Letter No. B 1/35754/2002

Sub: ~~XXXX~~ / Metropolitan Development Authority -
- Area Plans Unit - Planning Permission -
Proposed construction of Residential Building
of partly stilt floor + + partly Ground Floor
+ 3 floors + 4th Floor part with 10 dwelling
units at Door No.14, 8th Cross Street,
Shastry Nagar, T.S.No.27, Block No.34 of Urur
Village, Chennai - Development advice sent Charge
- Reg.

TYPICAL FLOOR PLAN SECOND AND THIRD FLOOR

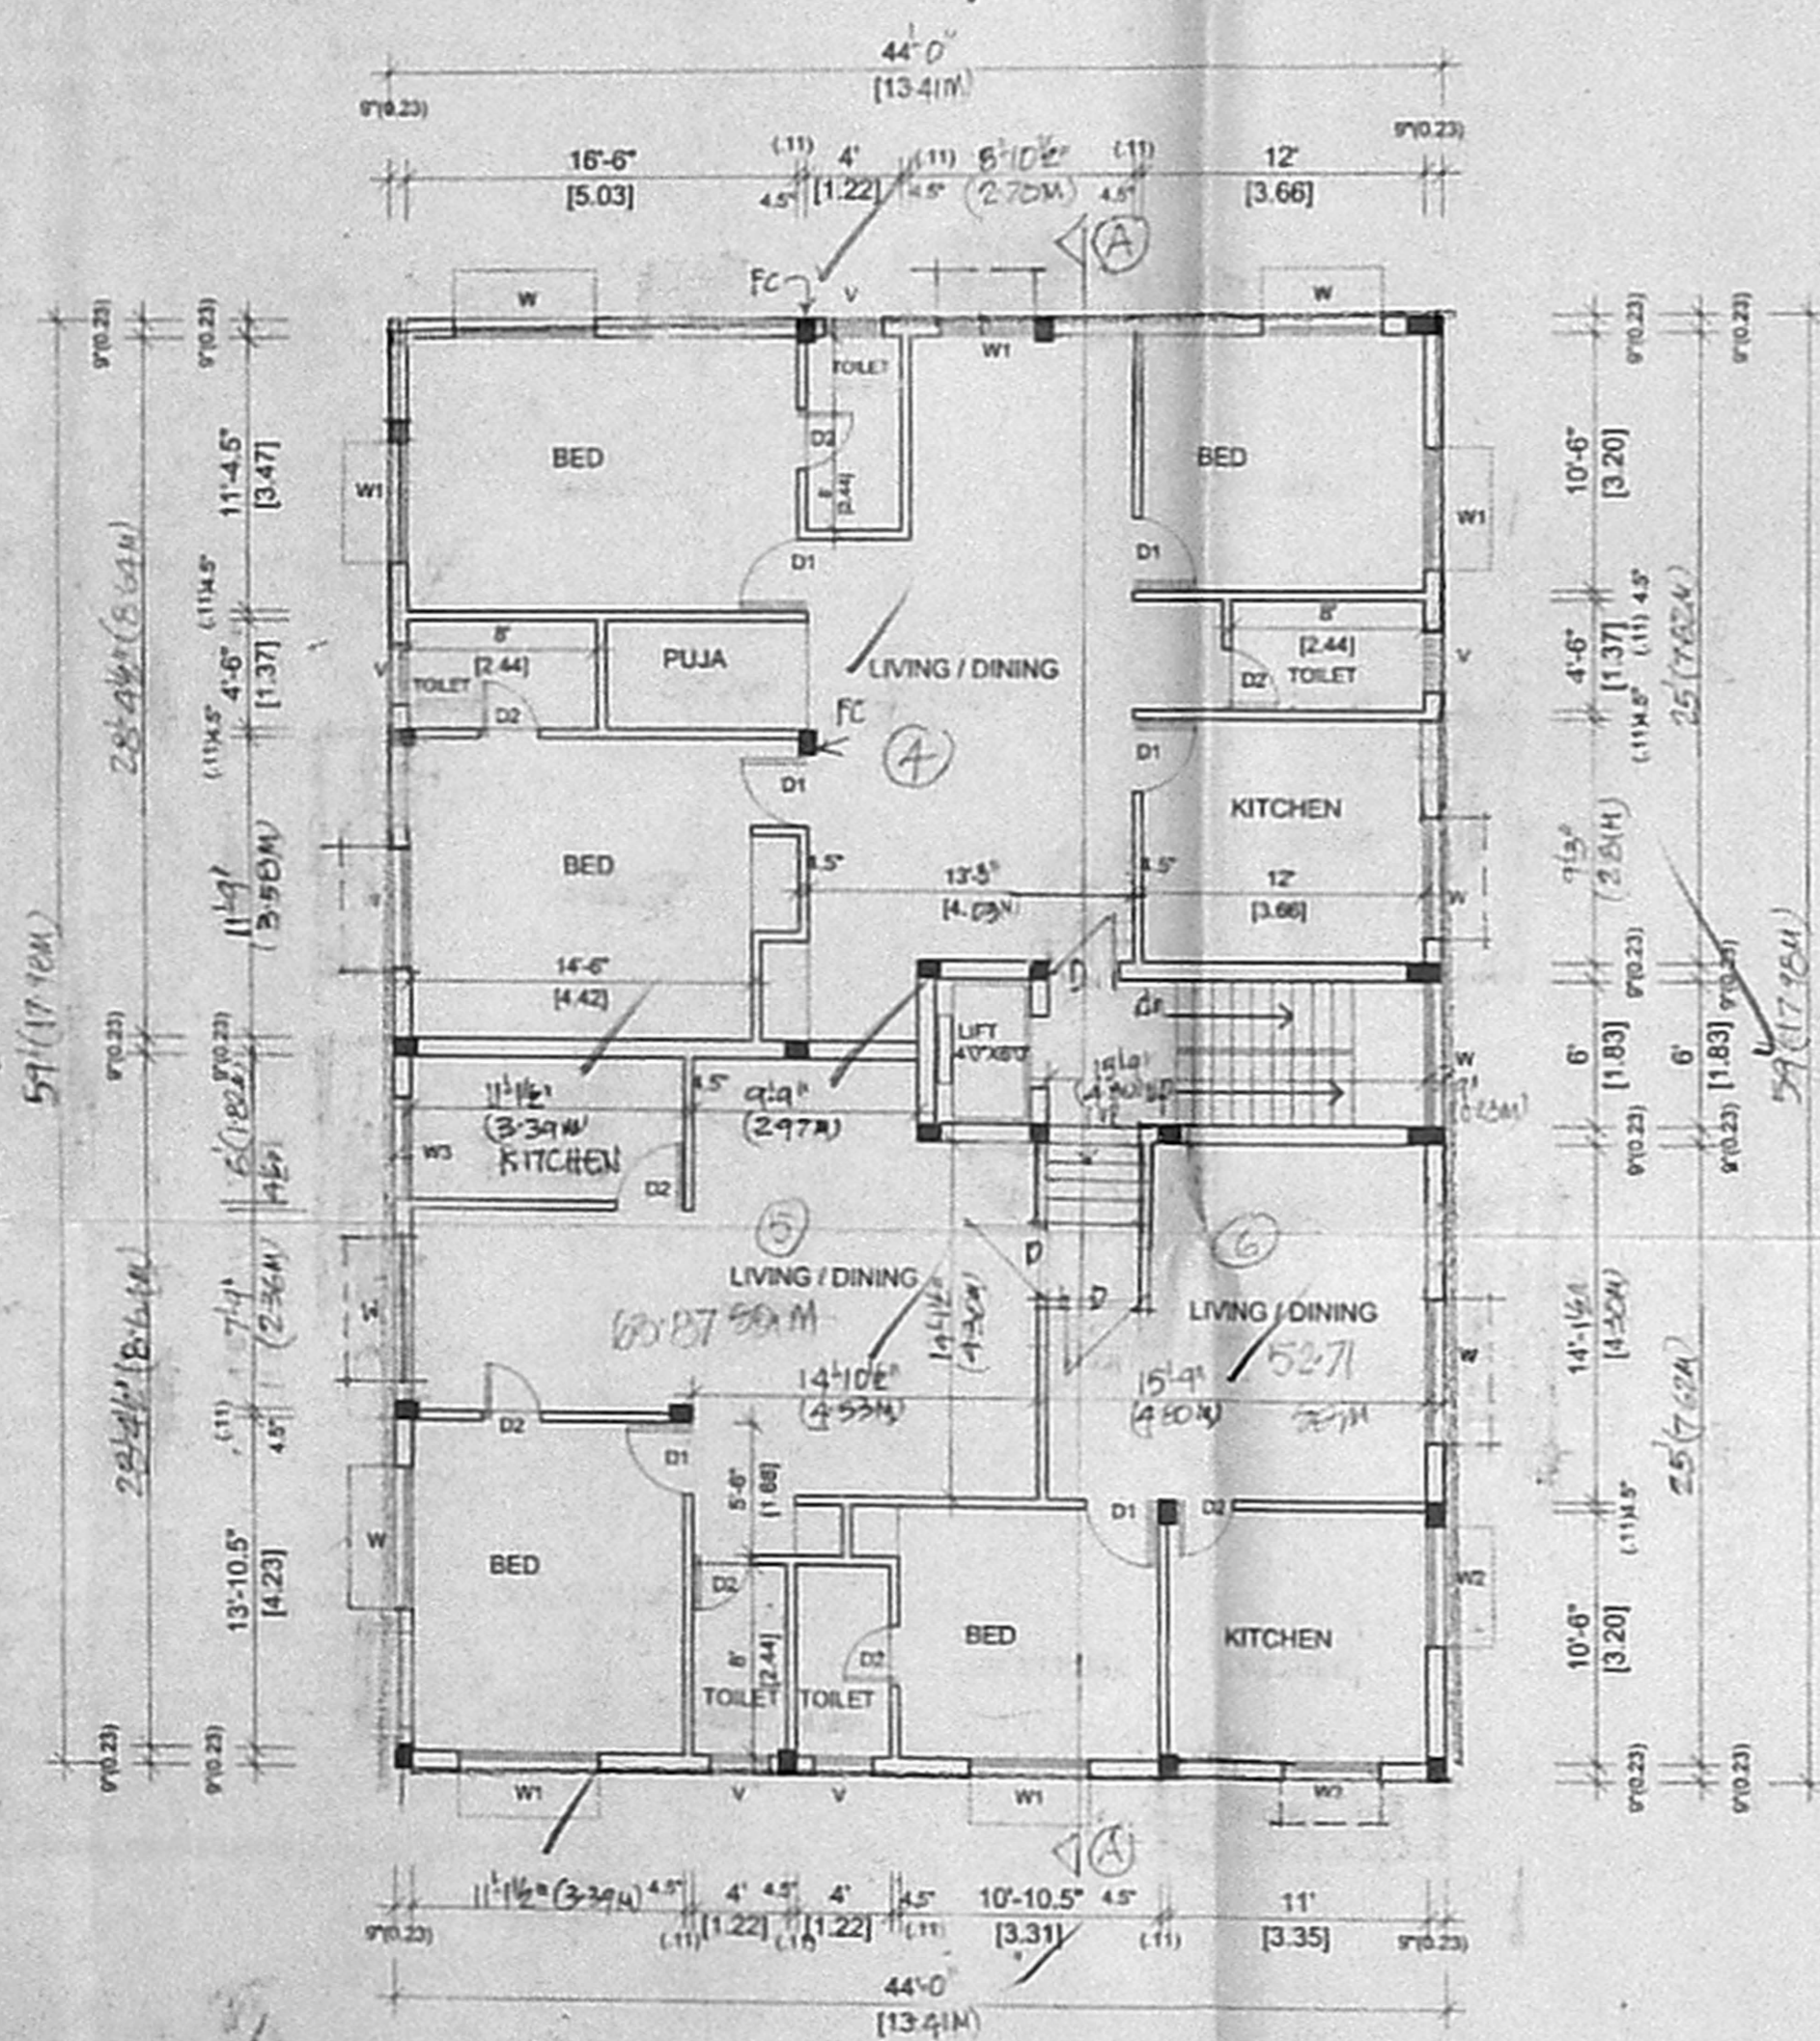
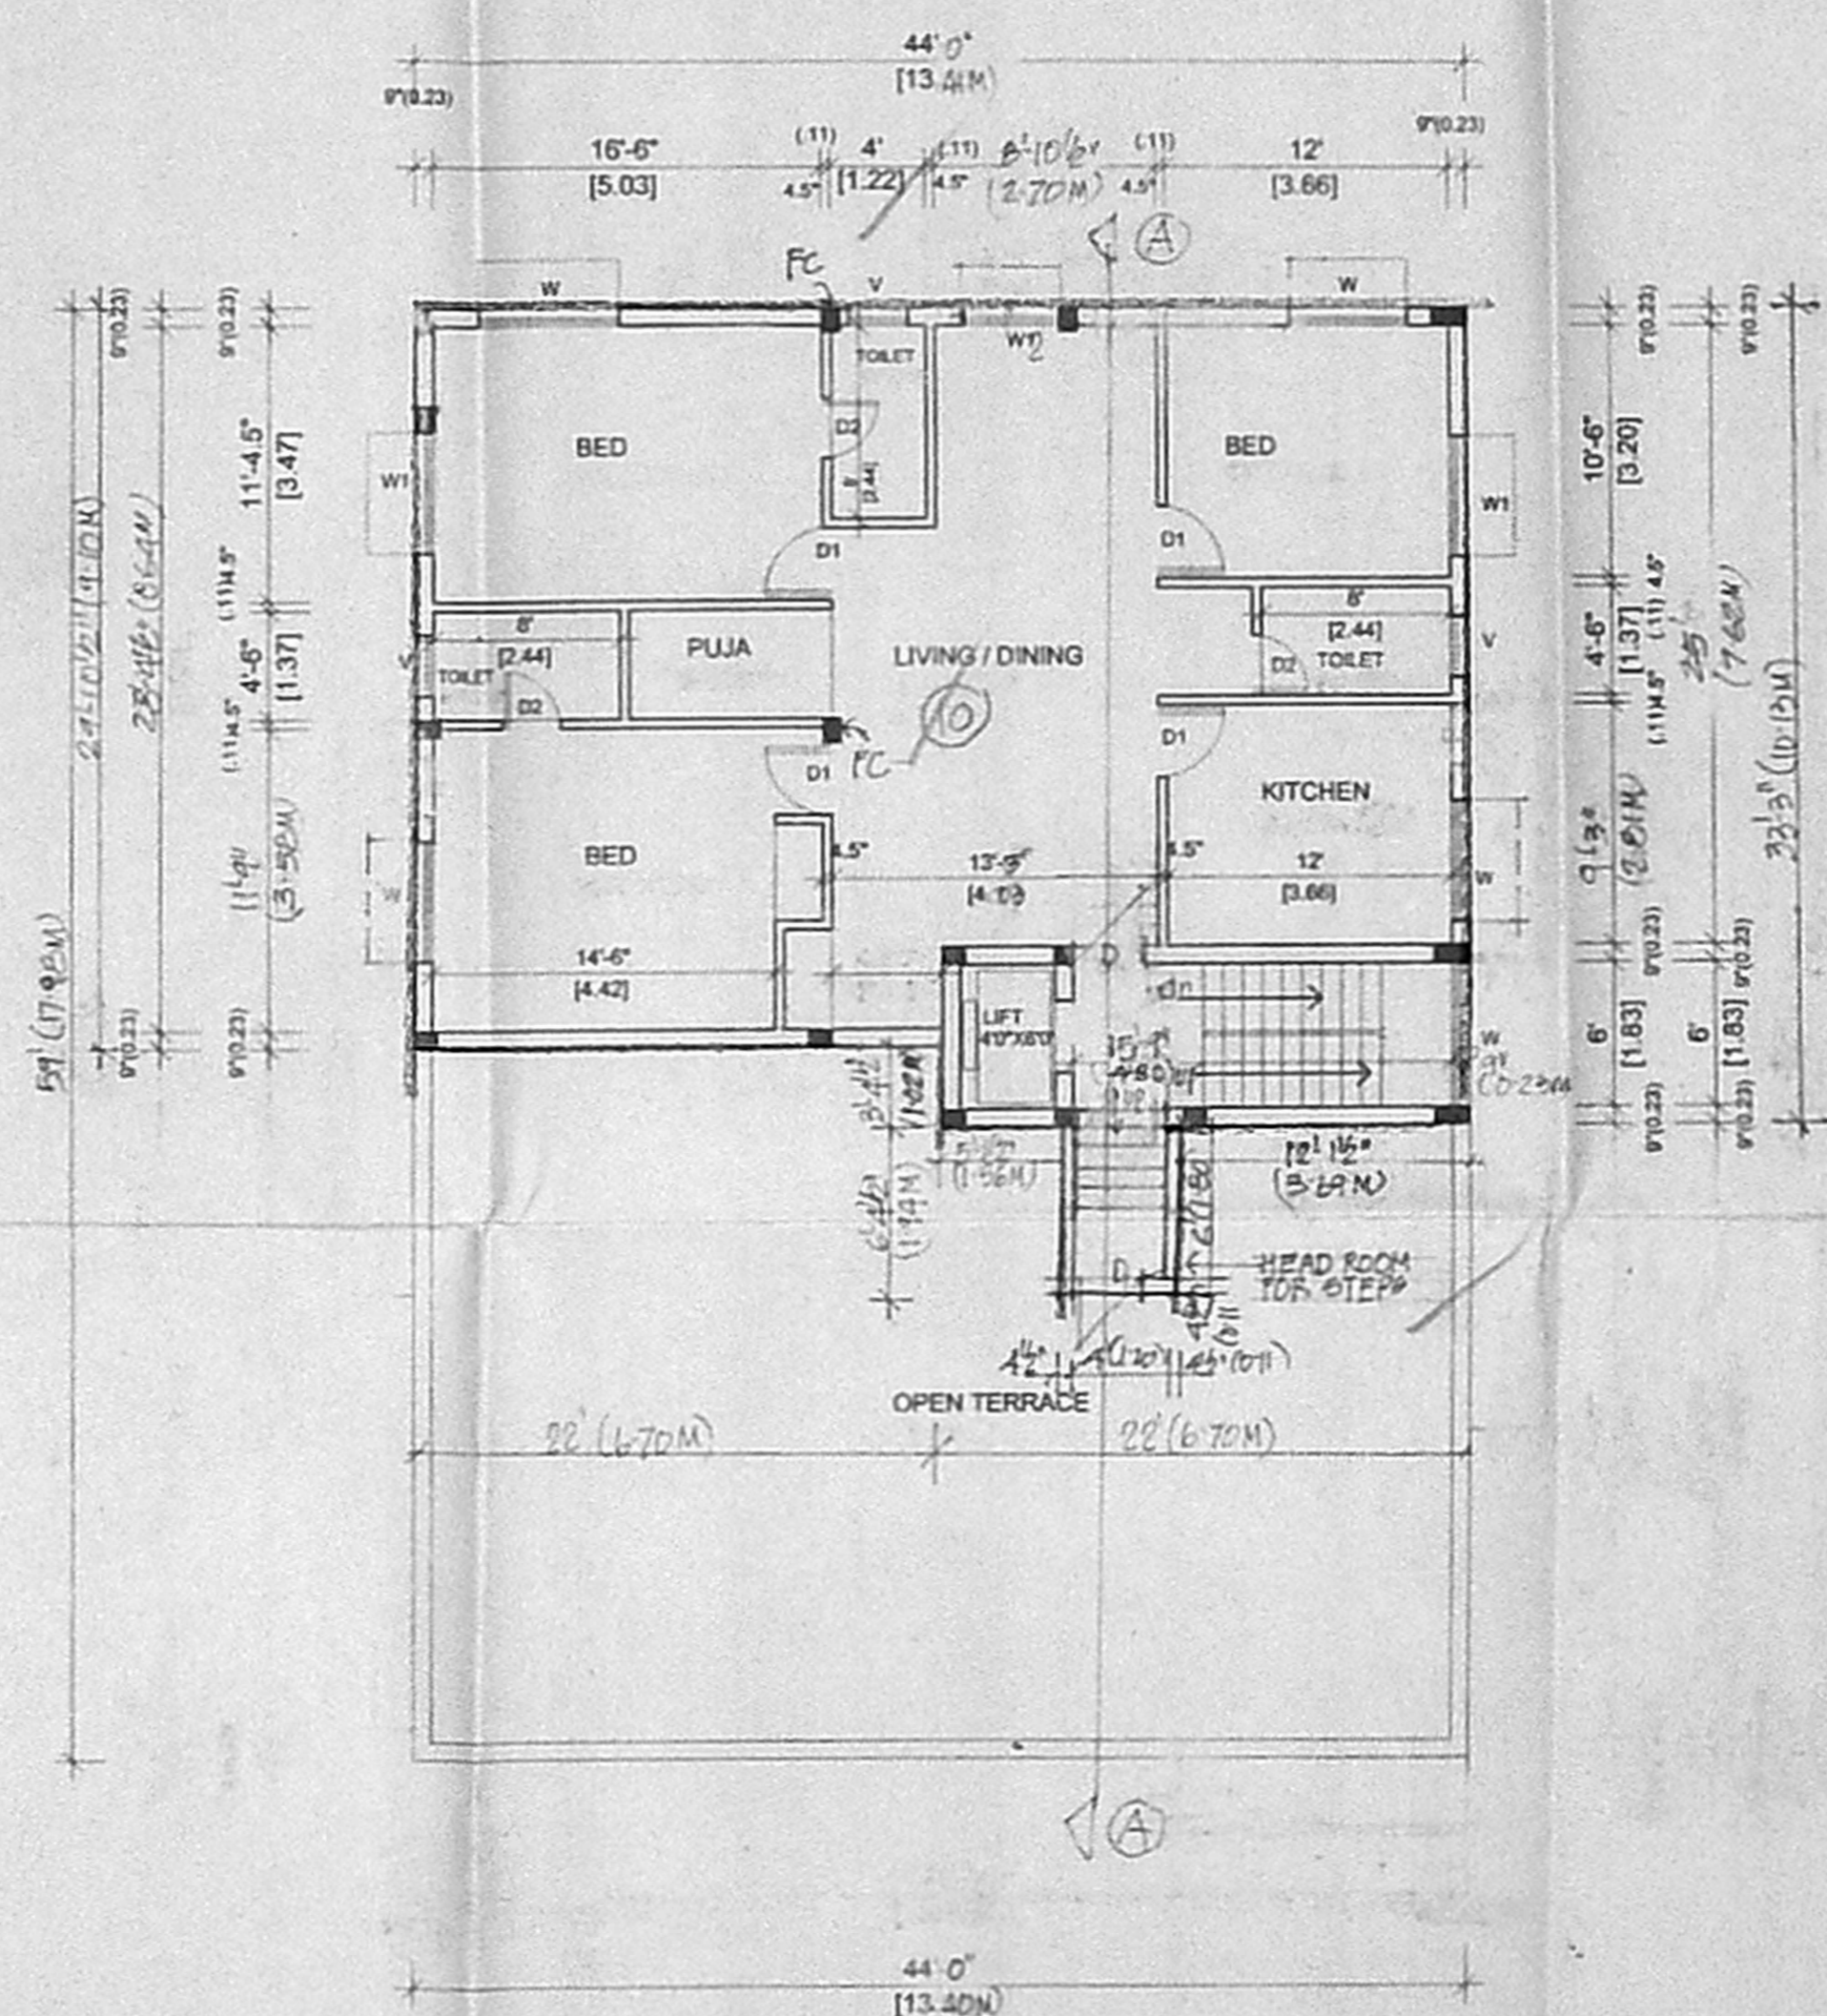
- i) Building break-up measurement does not tally with the total in First Floor to 4th Floor.
- ii) Roof plan to be renamed as terrace floor plan
- iii) Floating columns to be shown correctly.
- iv) Steps for head room to be removed from terrace floor plan and shown in the open terrace portion of fourth floor
